Summer Lane – Drainage Comments From Paul Cann (12th May 2020)

Response Not further action

Information will be provided by Drew Smith

Drawing Title:-
SuDS FEATURES
HEADWALL
CONSTRUCTION DETAILS
SHEET 1 OF 2

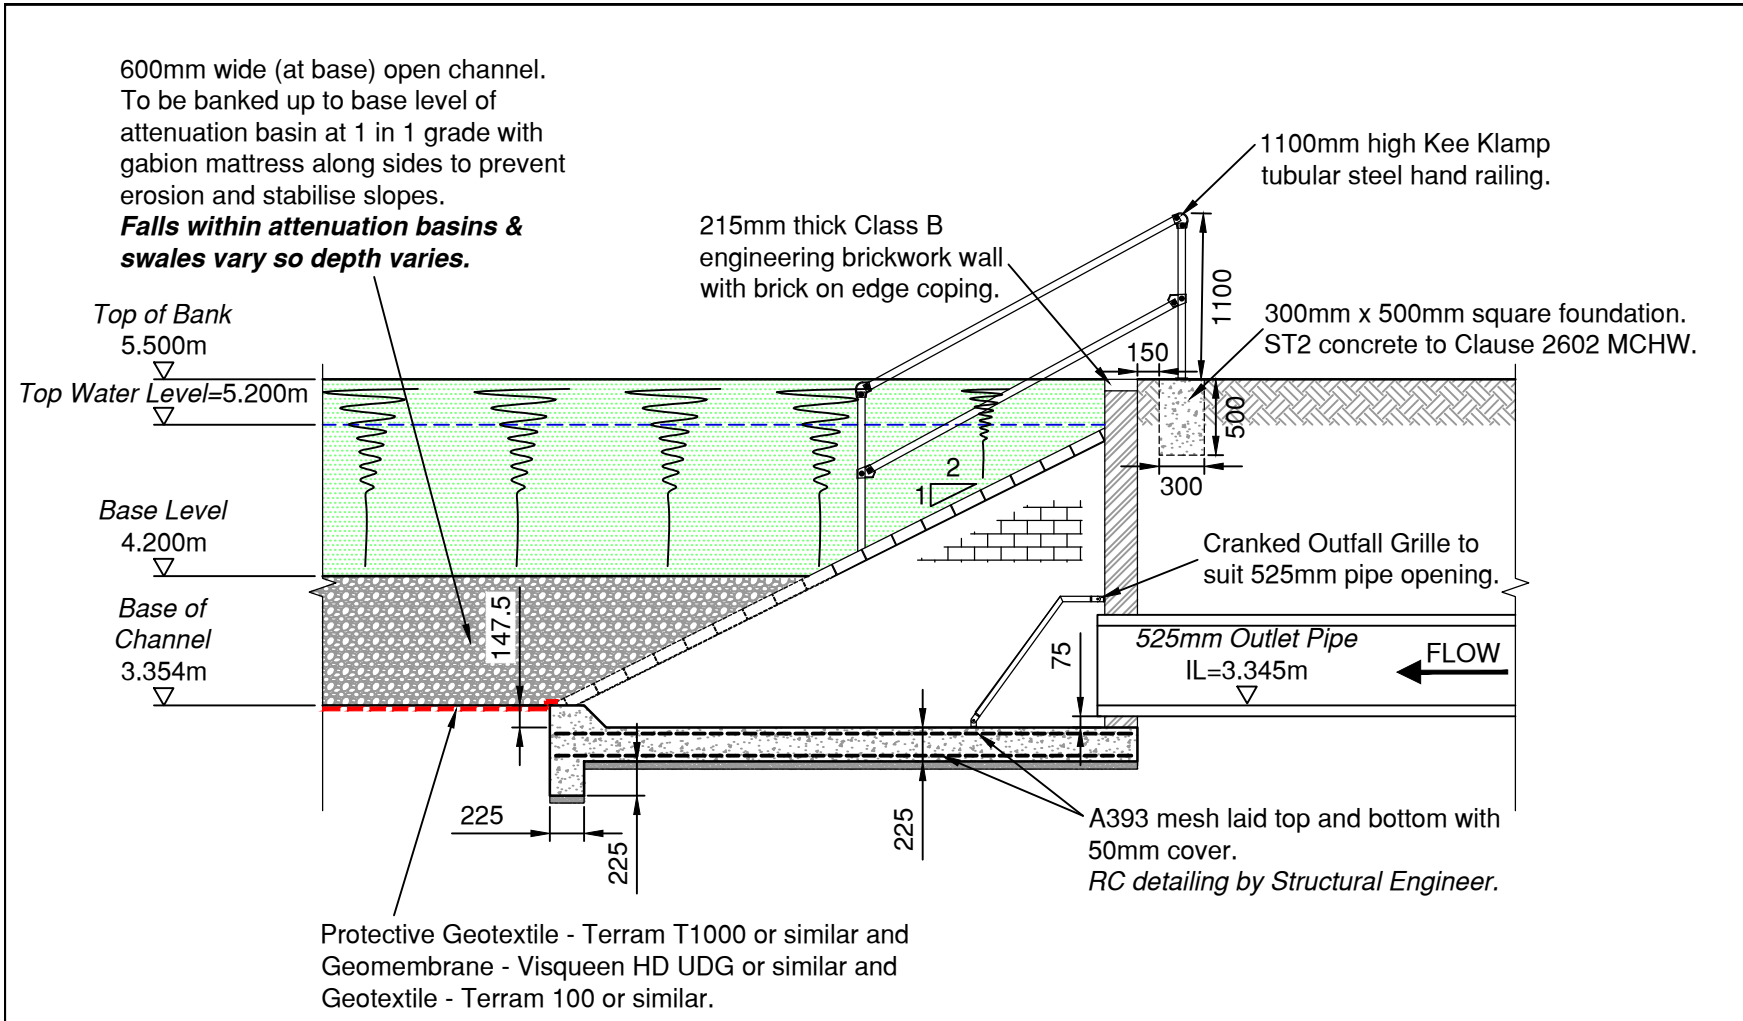
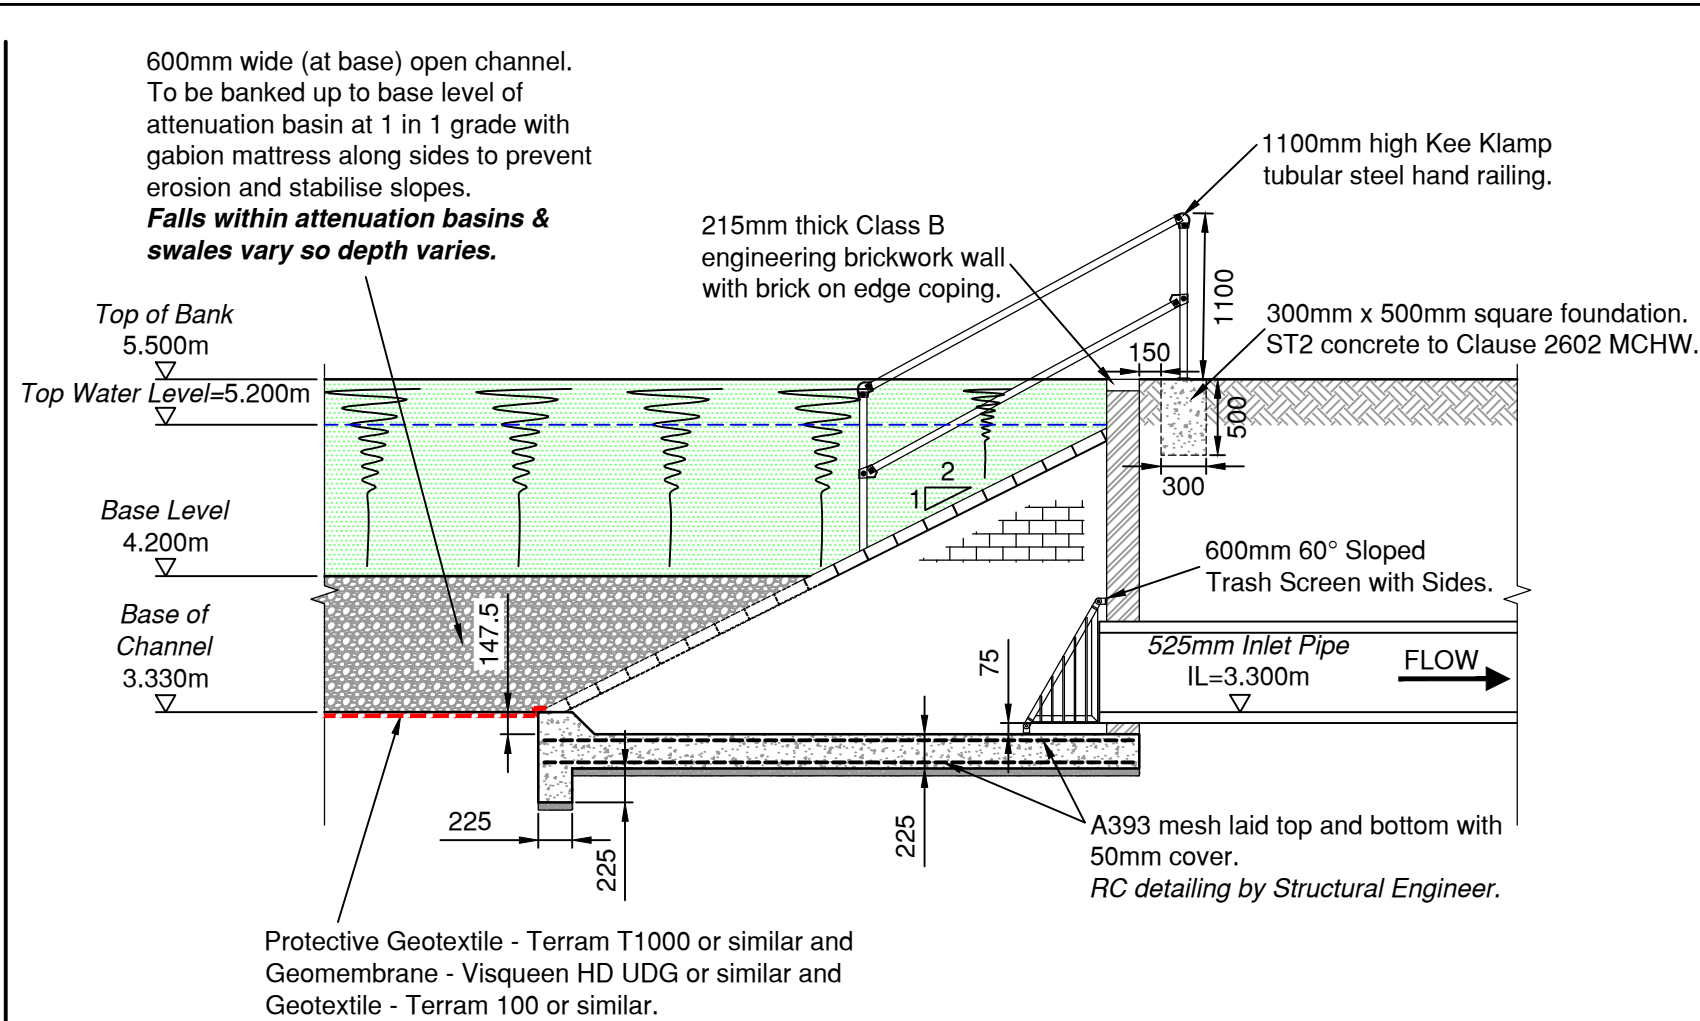
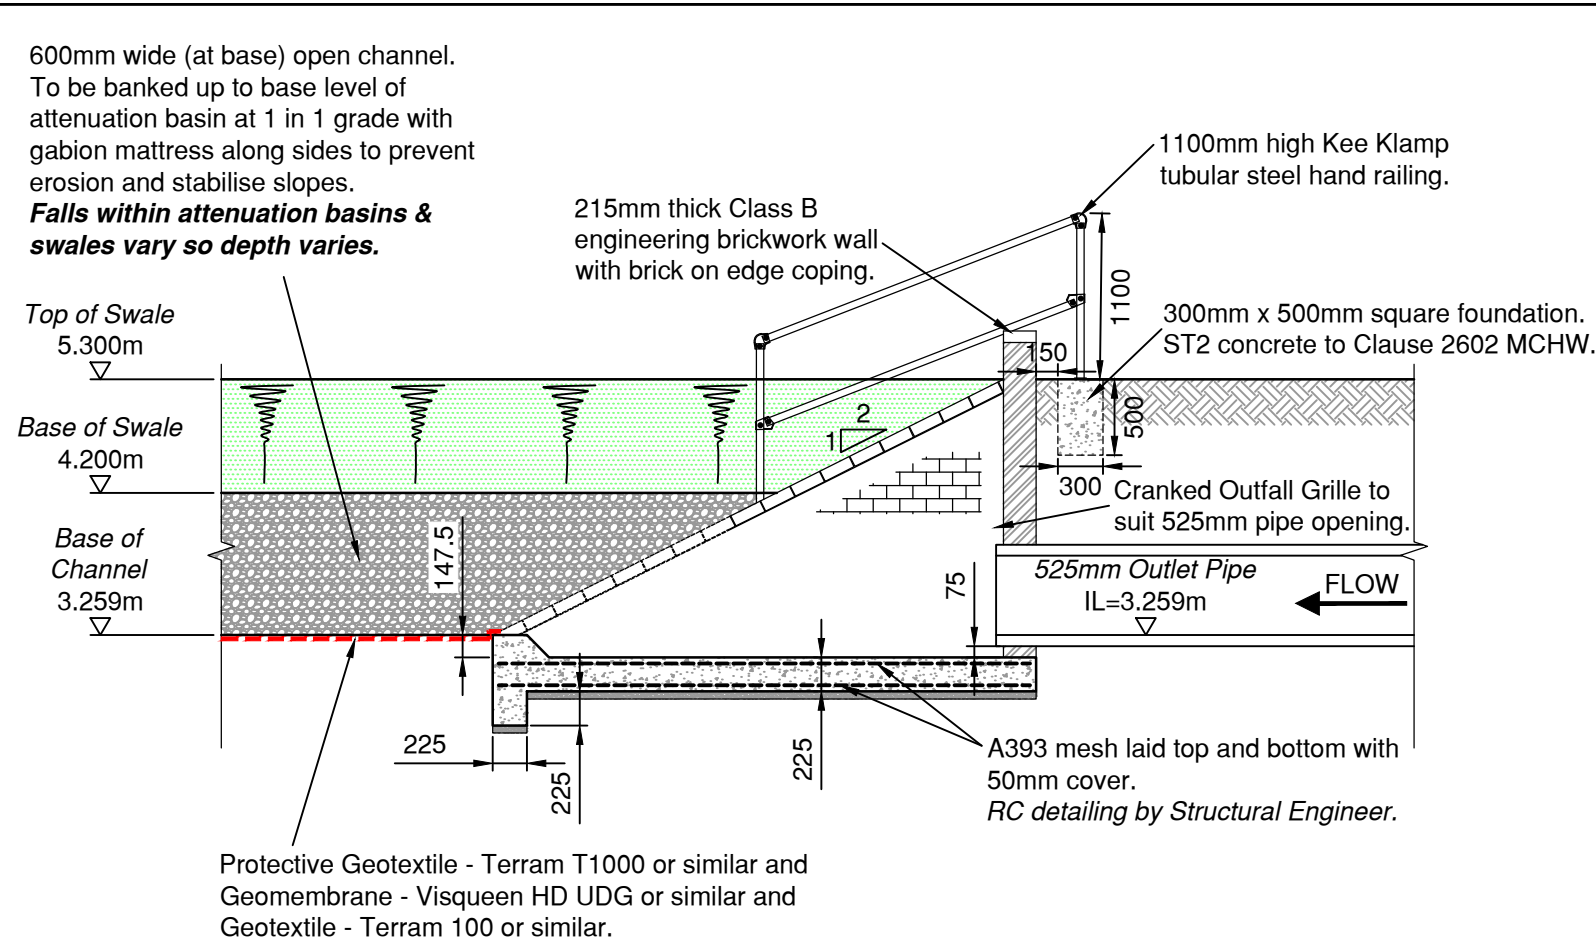
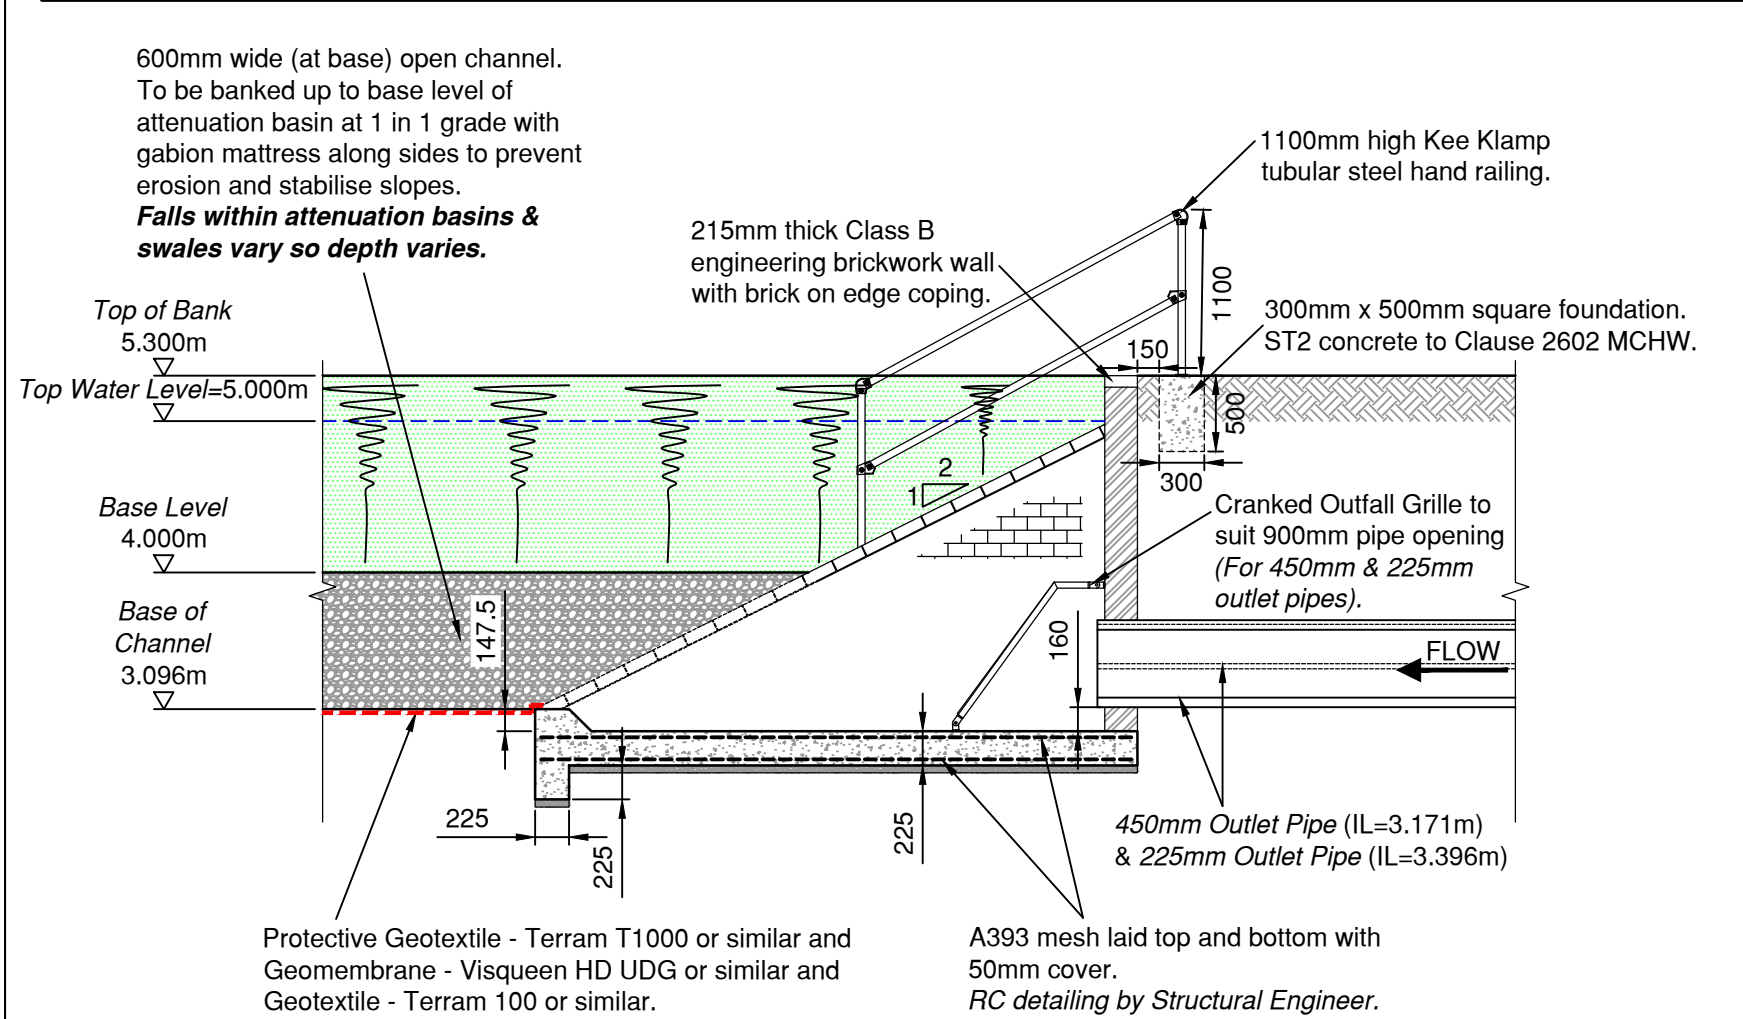
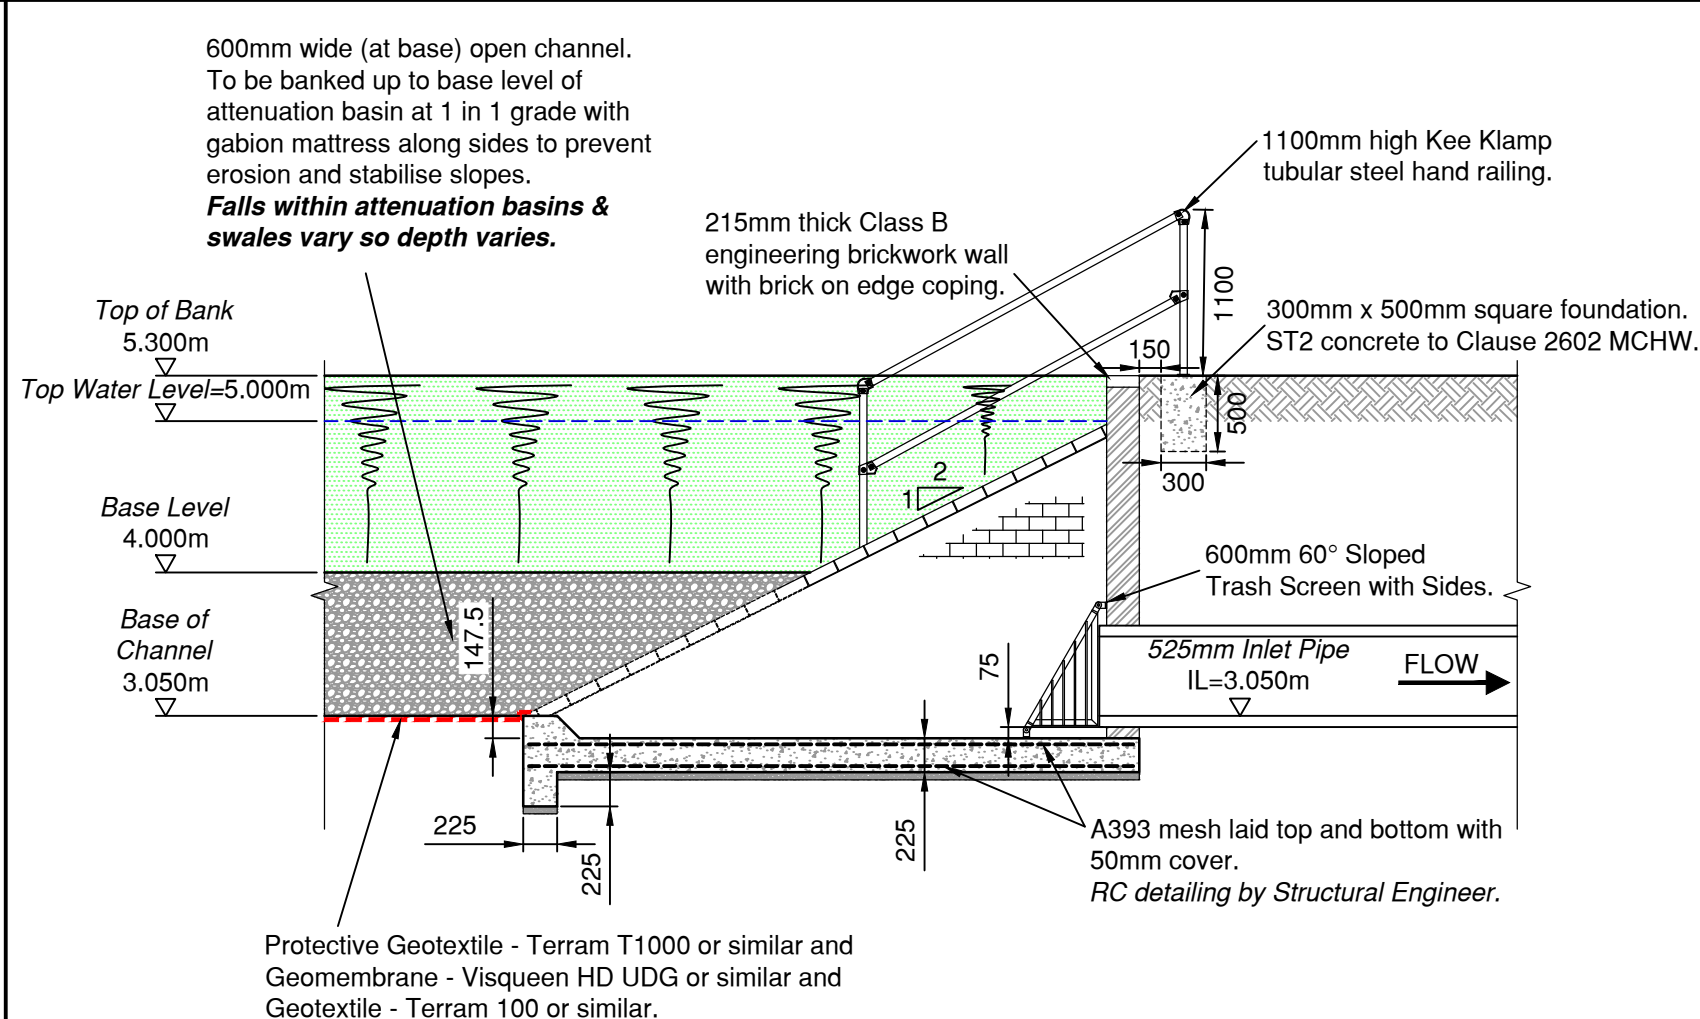
9. All headwall grilles to be cranked as opposed to be flat or just sloped faced. Headwalls SW-4, SW-5, SW-9, SW-13, SW-29 and SW-32 updated to cranked grilles.

12. All headwalls - 50mm cover required to reinforcement. Drawings 433 and 434 updated with concrete cover note increasing from 40mm to 50mm.
13. All headwalls – Dimension and specify concrete for hand railing foundations. Dimension handrail height above ground level and offset from brickwork. Drawings 433 and 434 updated with handrail dimensions and foundation annotation.

17. Incoming pipes at headwalls SW-4, SW-5 and SW-32 – increase freeboard between pipe inverts and basin/swale bed. The base of the pipe work connects to the drain bed level, which is specifically deepened to accommodate the incoming pipework levels and eventually connect onto the downstream watercourse. This is a similar arrangement to the main drainage channel running through the swale associated with headwalls SW9 and Sw13.
